Planning Application Ref: WA/74/18/T

Location: Walberton Place Nursing Home, Yapton Lane, Walberton, West Sussex BN18 0AS

Description of works: Various works to 7No. Lime, 5No. Sweet Chestnut, 3No. Oak & 1No. Sycamore

Drawing title: TPO Map

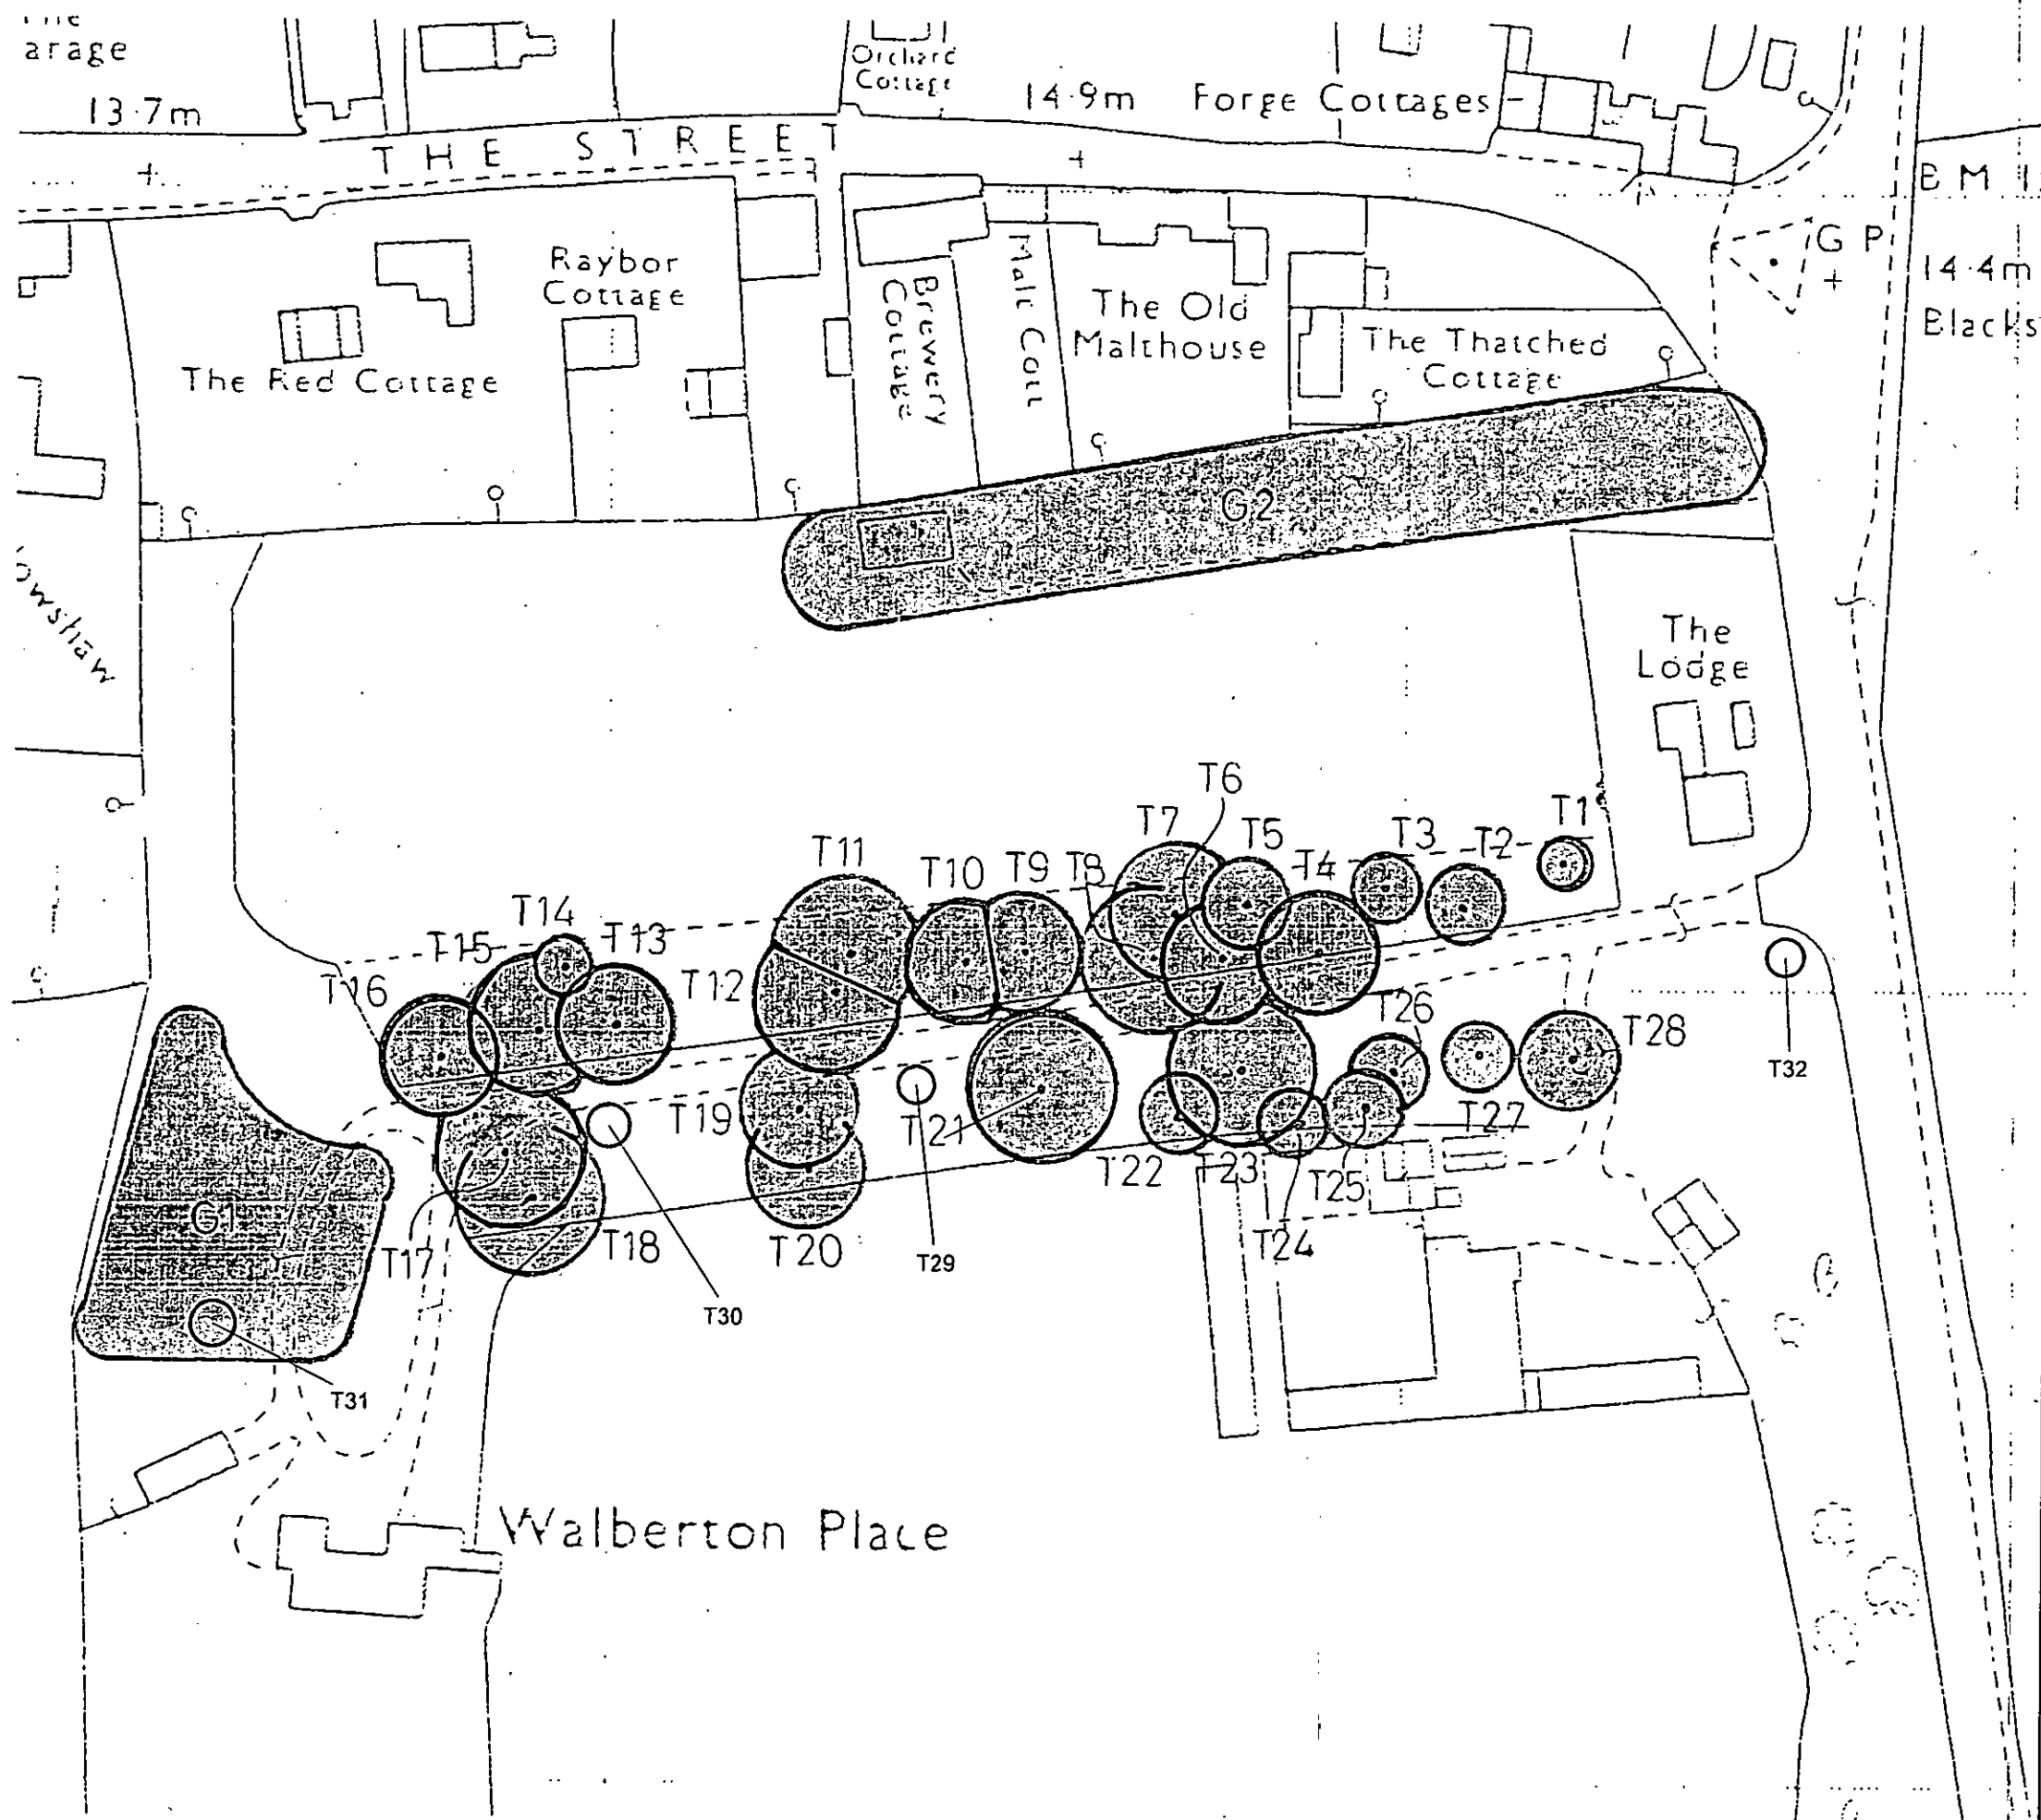
- There are a large number of trees included in this proposal. The management recommendations within the submitted Tree Survey Schedule and supporting TPO Map (PJC Consultancy, July 2018) were simultaneously considered during my site assessment. The information contained therein appears accurate and I concur with the findings.
- No individual trees are worthy of specific comment for the purposes of reviewing this application; all can be satisfactorily considered for generic comment, as follows.
- There are a healthy number of individual trees of merit within this site, many of which form a cohesive high canopy that is prominent and visible from the surrounding area.

- The proposed programme of work represents a balanced approach to accommodating the development and maintaining adequate site access for high-sided vehicles.
- The work proposed is justified and if undertaken to a high standard will not incur a noteworthy loss of amenity value to the surrounding area.

- I recommend **CONSENT** for this application, subject to the following conditions being applied:

- Where whole branches are to be removed and final cuts made close to the trunk or branch union they are to be made as shown in Figure 2 of BS3998:2010
- Where branches are to be shortened back the final cuts are to be made at the correct angle shown in BS3998:2010 and adjacent to a live bud or lateral.
